Kimbriki Resource Recovery Project

I refer to your letter dated 15 February 2011 in relation to the Environmental Assessment for the Kimbriki Resource Recovery Project (Project) proposed by Kimbriki Environmental Enterprises Pty Ltd (KEE) at Kimbriki Road, Terrey Hills (KEE Site).

COUNCIL'S SUBMISSION ON PROJECT

Figure 5.2 - Resource Recovery Facility and Maturation Site

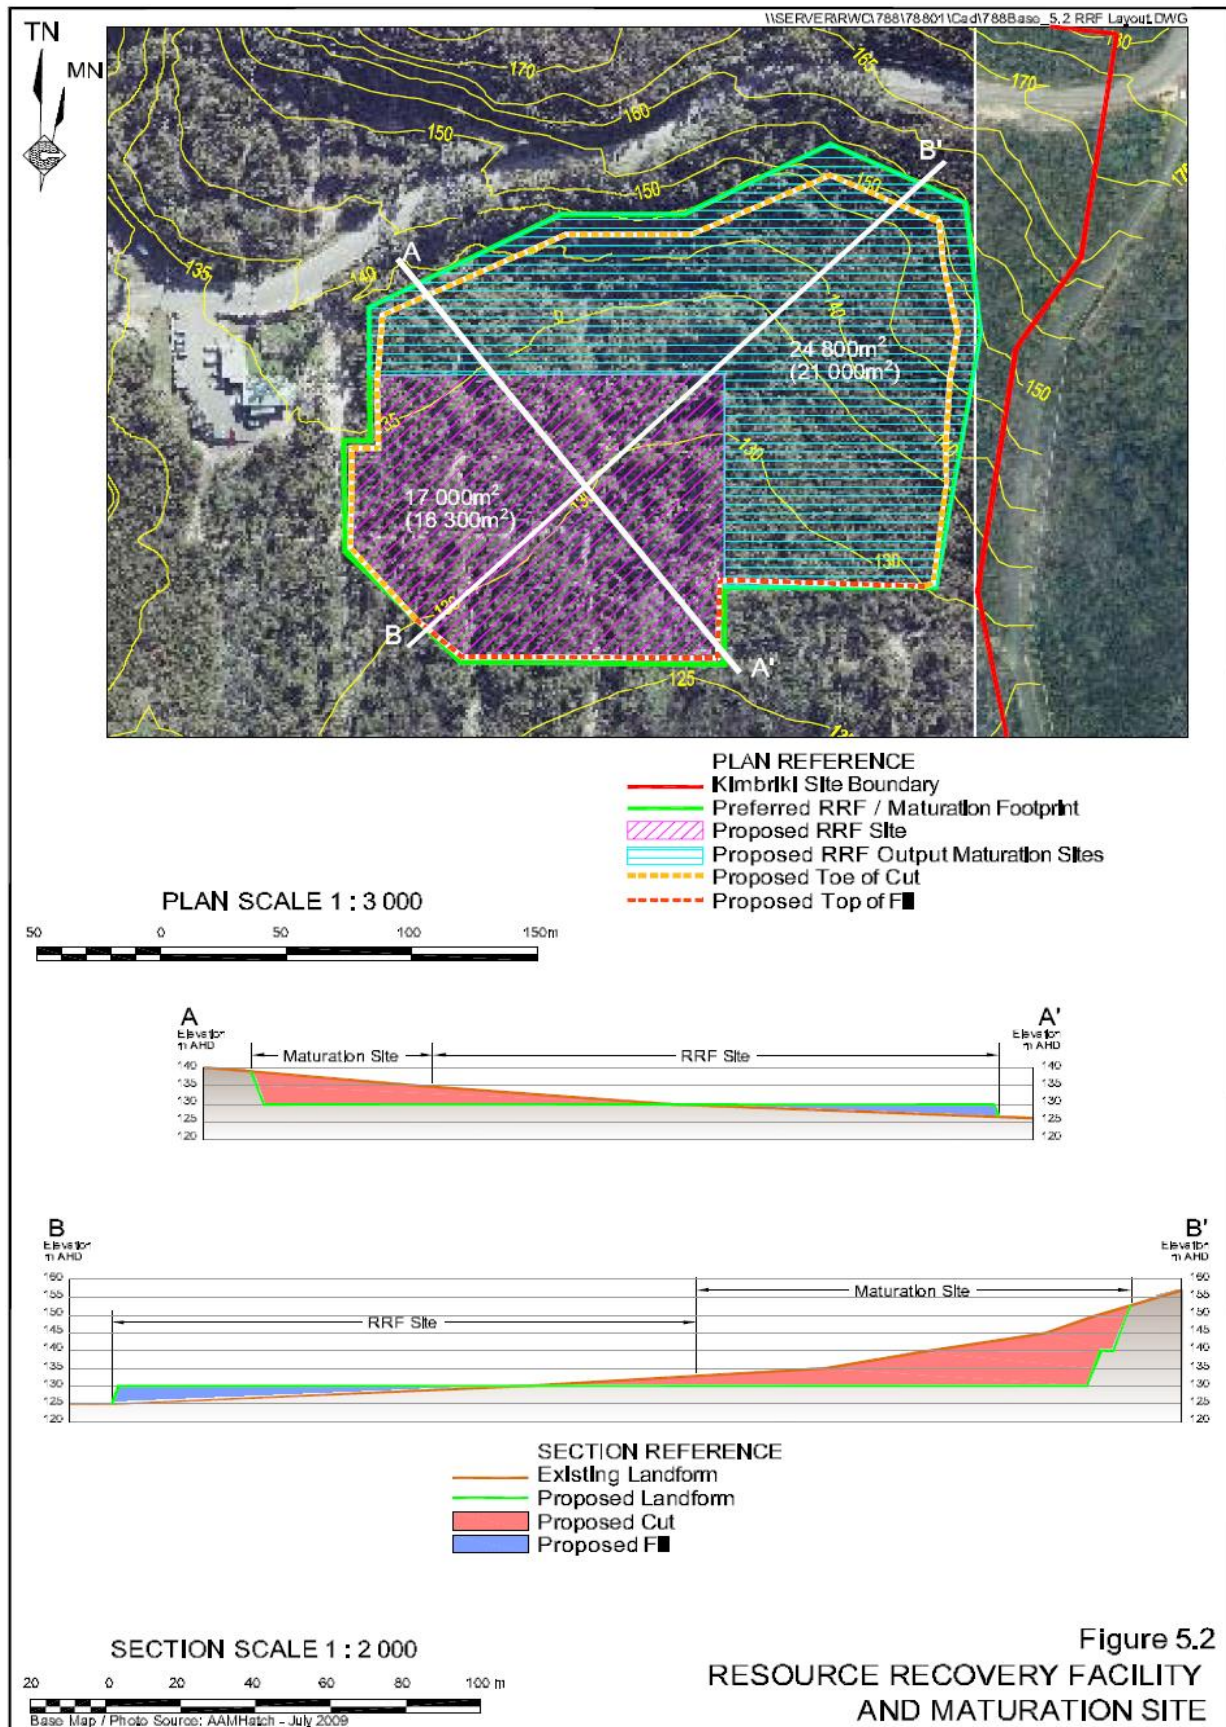
The Environmental Assessment proposes that the Maturation/Final Processing Building and Amenities Block will be built over the upper reach (or catchment) of Deep Creek, including over the Wetland.

It is Council's view that the facility would need to be relocated away from the Watercourse and the Wetland if it is not to have any effect on Deep Creek and Narrabeen Lagoon, unless it can be demonstrated that the facility will not have any effect on those features.

It is considered that the Car Park, Ramp, Weigh Bridge and AWT Building would also have an effect on the core riparian zone and riparian buffer land and should be moved away from these areas, unless it can be demonstrated that the facility will not have any effect on those features.

It is considered that the location of the Maturation/Final Processing Building and the Amenities Building would need to be relocated outside of the Watercourse and riparian land in order for these principles to be achieved, unless it can be demonstrated otherwise.

Figure 6.1 - Vegetation Communities, Threatened Species and Preferred Footprint

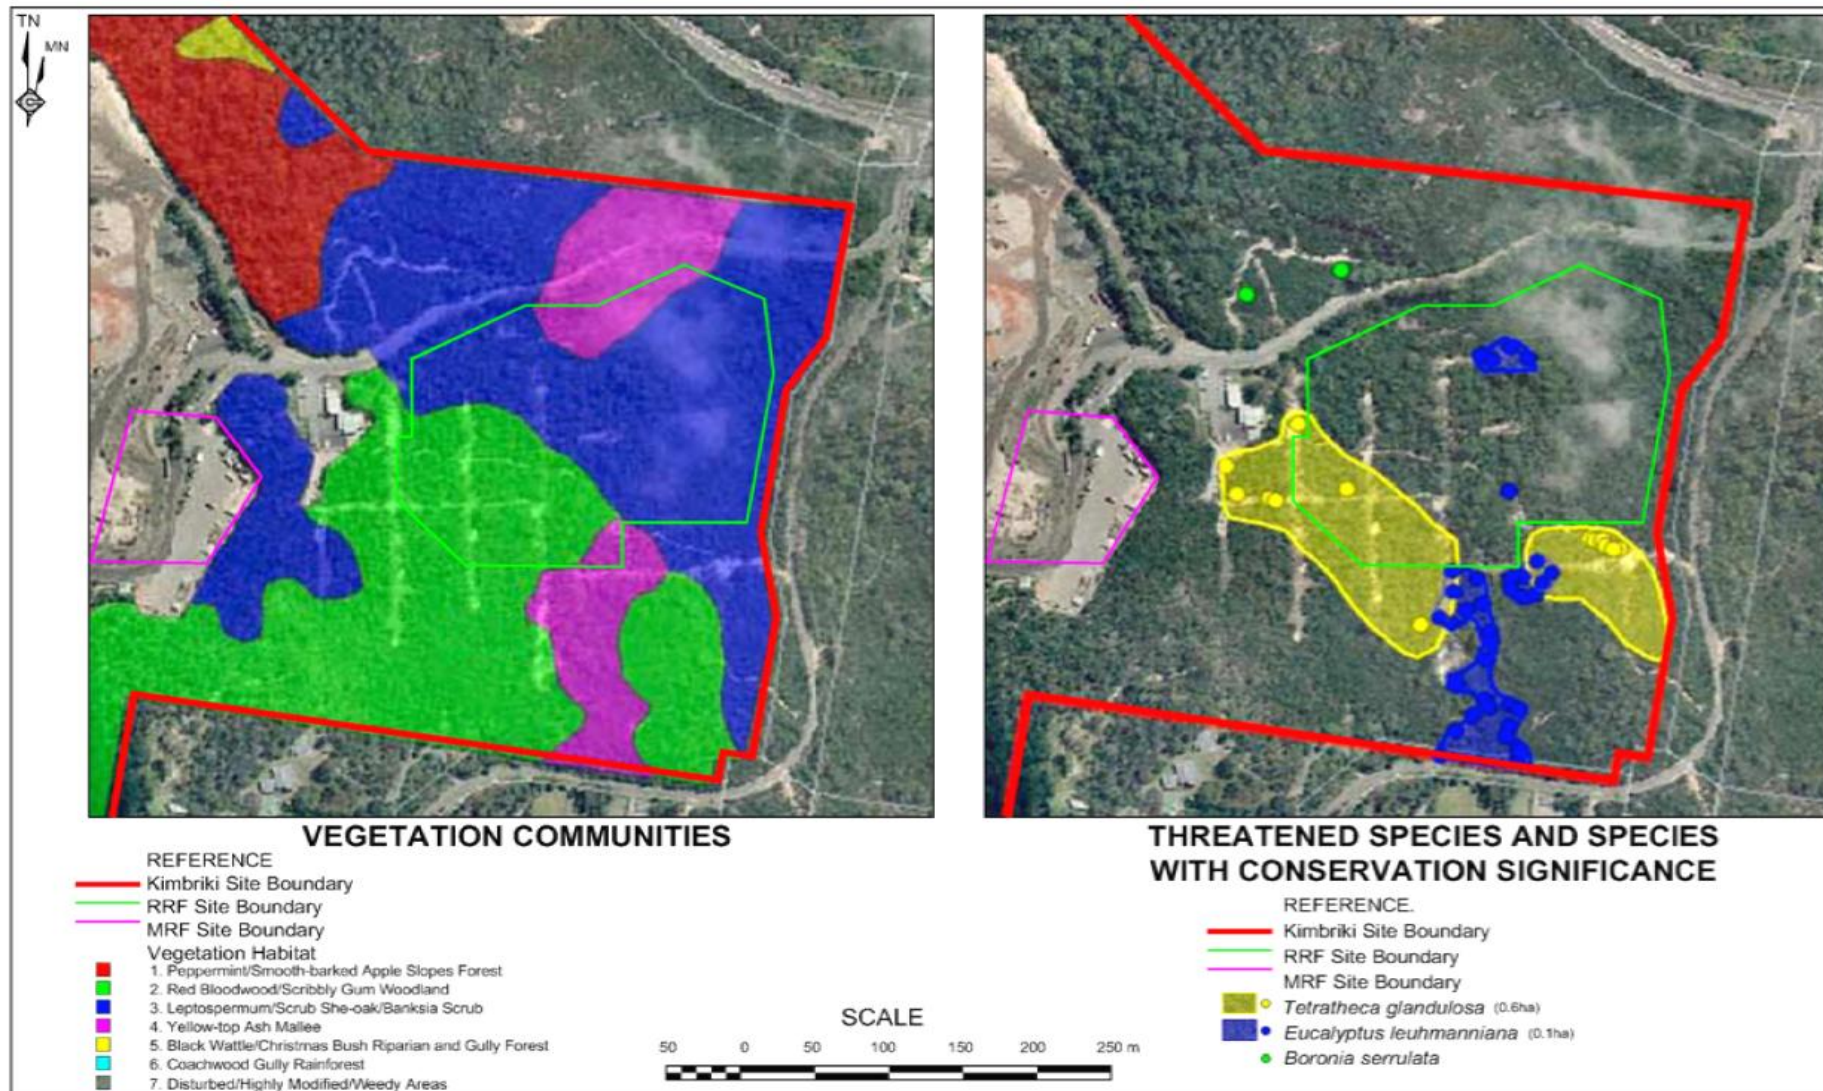
It is considered that the removal of significant areas of vegetation in and around the Wetland, the erection of buildings and the associated landform works would impact on natural hydrological flows which sustain the groundwater dependent ecosystems associated with the Wetland and Watercourse.

The KEE Site is located within a significant bushland remnant and any development in this area would unavoidably result in some level of fragmentation. Whilst the proposed amended location of the facility will result in the fragmentation of remnants to the north, south and east of the site, Council acknowledges that north-south connectivity will be maintained around the perimeter of the facility.

Tetratheca glandulosa is a listed threatened species under both State and Commonwealth legislation. A *Tetratheca glandulosa* retention area is proposed in the KEE Site. Council understands that this approach is supported by the relevant Commonwealth agency and considers that it is not unreasonable in the circumstances.

Figure 6.2 - Offset Areas

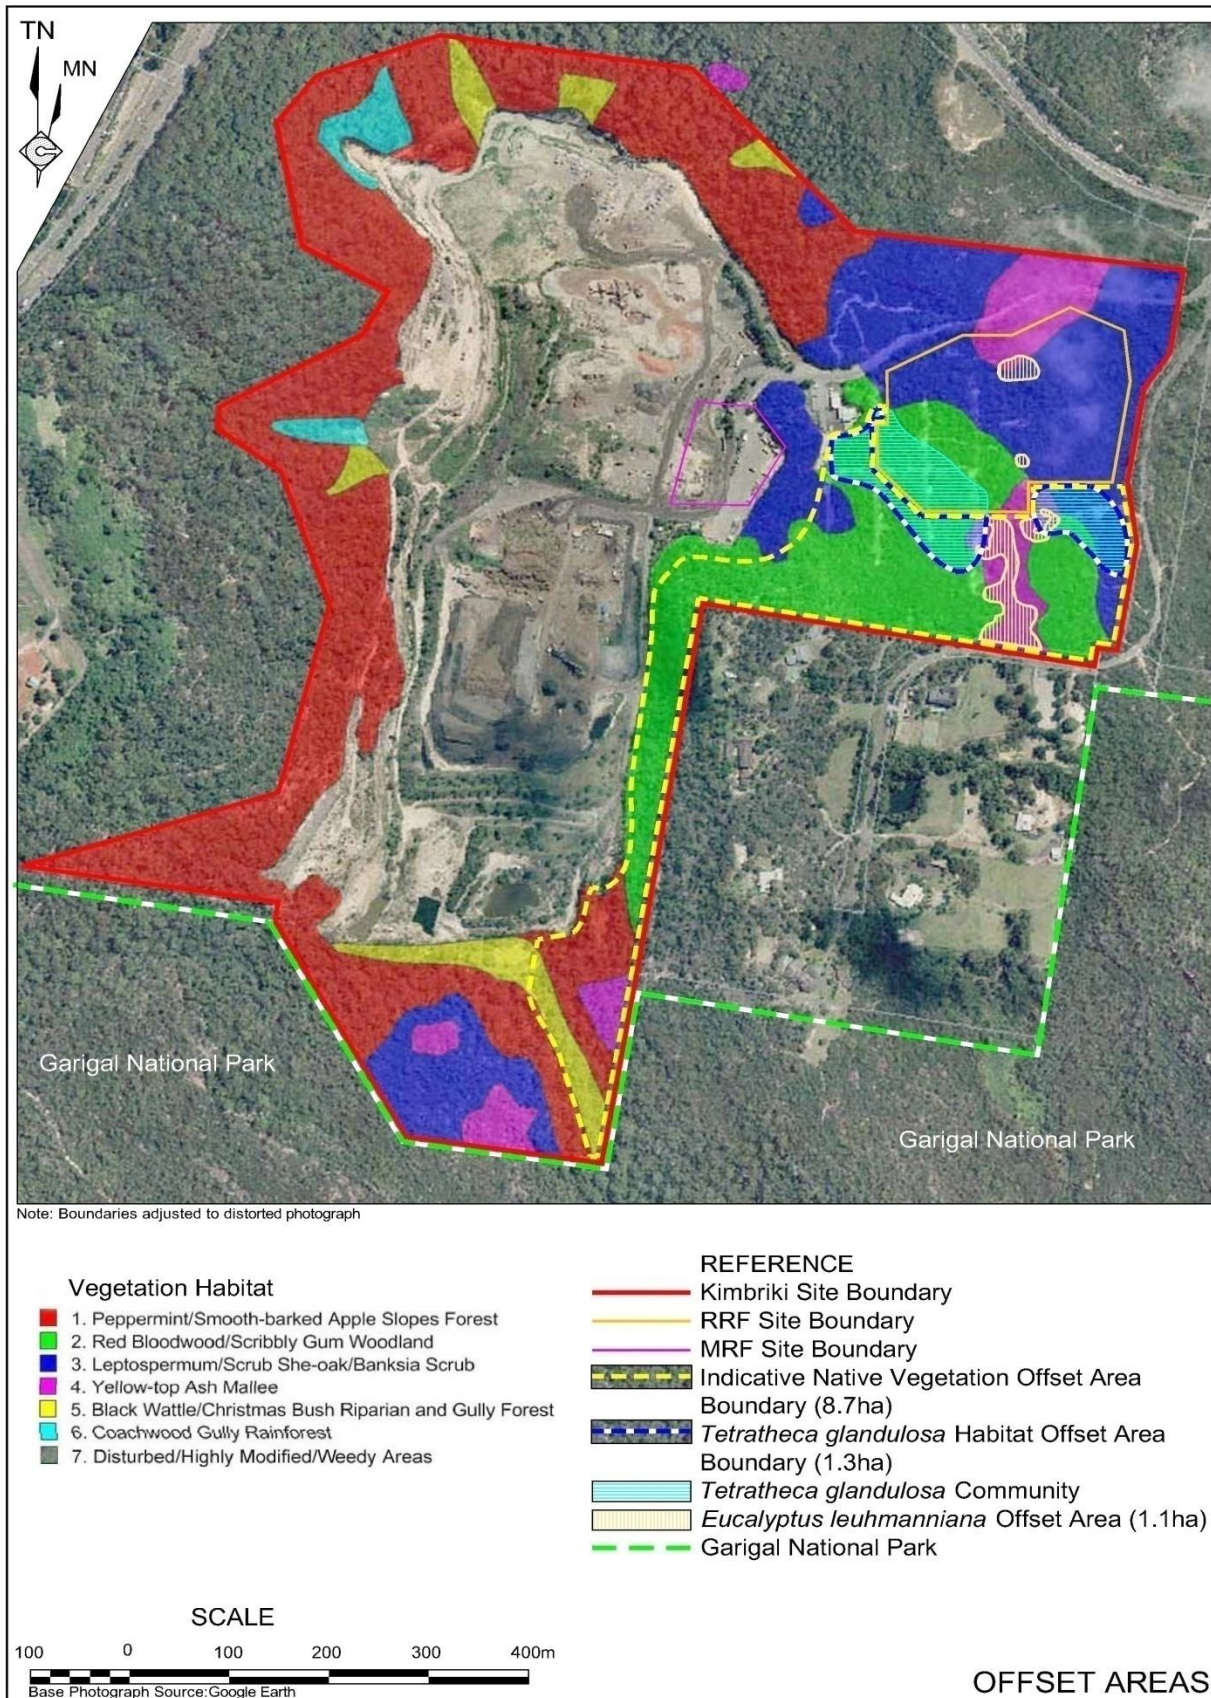
Offset areas should generally be representative of the vegetation being removed. However, the majority of the offset areas proposed by KEE are comprised of a vegetation community which is not affected by the Project and do not necessarily contain threatened species habitat consistent with that which is proposed for removal.

Offsets may include the provision of finance to manage similar habitats outside of the affected site, where similar habitat types are not readily available within the affected site. Accordingly, alternative offset sites could be considered by KEE.

Council environment staff should be consulted in the design of the offset and the development of the proposed Biodiversity Management Plan for the offset areas.
